Mrs Barbara Thorpe
Dene Cottage
156 Sea Road
East Preston
West Sussex BN16 1PB

Planning Inspectorate
Room 3/20 Eagle Wing
Temple Quay House
2 The Square
Temple Quay
Bristol BS1 6PN

RE: APP/C3810/A/12/2181653/NWF
(EP/136/11)

EAST [sea road frontage] 1/100

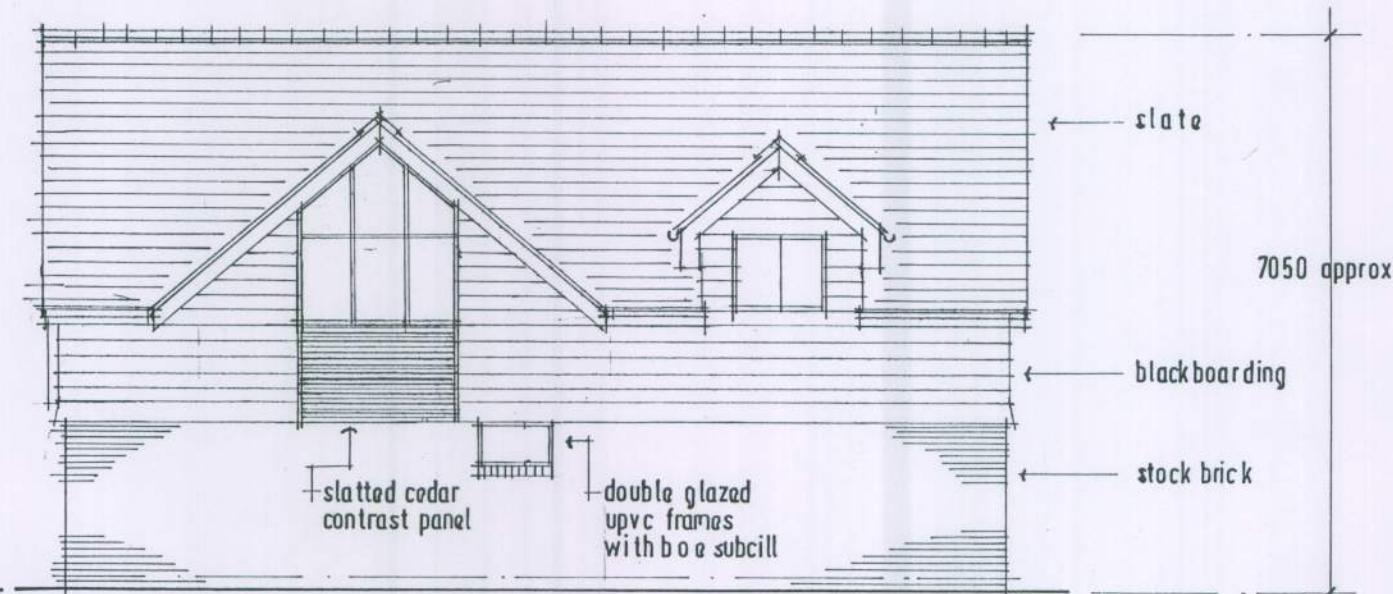
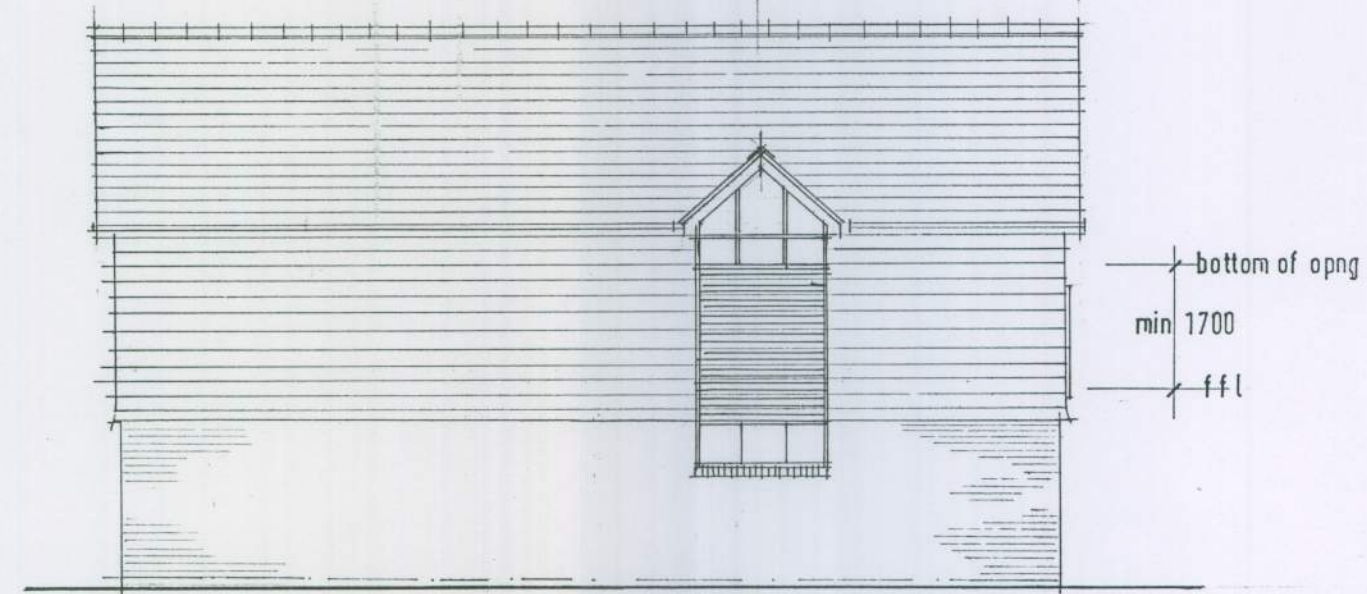
In the plans, it is unclear as to the exact position of the new property in relation to all the boundaries. Also the overall measurements of height etc need clarification. It is difficult to ascertain from the application exactly where the new property is to be situated as it appears to have the entrance for vehicles on Seafeld Road but the pedestrian entrance on Sea Road. The traffic at this end of East Preston is already a problem for residents. Sea Road is a small lane leading down to the beach which is only one car's width and is a dead end. It already supports both cars, lorries and caravans for the Seaview Pub and its car park, the Caravan site and car park, Dinghy Club and drop offs to the beach (please see attached map). The eastern end of Seafeld Road is a permanently gated road with just enough space beyond the gates for cars to turn around in order to get back out of Sea Road or to move aside for other vehicles.

The proposed building will be extremely over-bearing and un-neighbourly to my home and garden. It would ruin the view I have now. It will have a detrimental effect on the appearance and character on both Sea Road and Seafeld Road and over-dominate land intended for garden space. The property will be cramped within the plot and Crinnis would be left with minimal garden in comparison to its house size. (Does this set an example for future planning applications?).
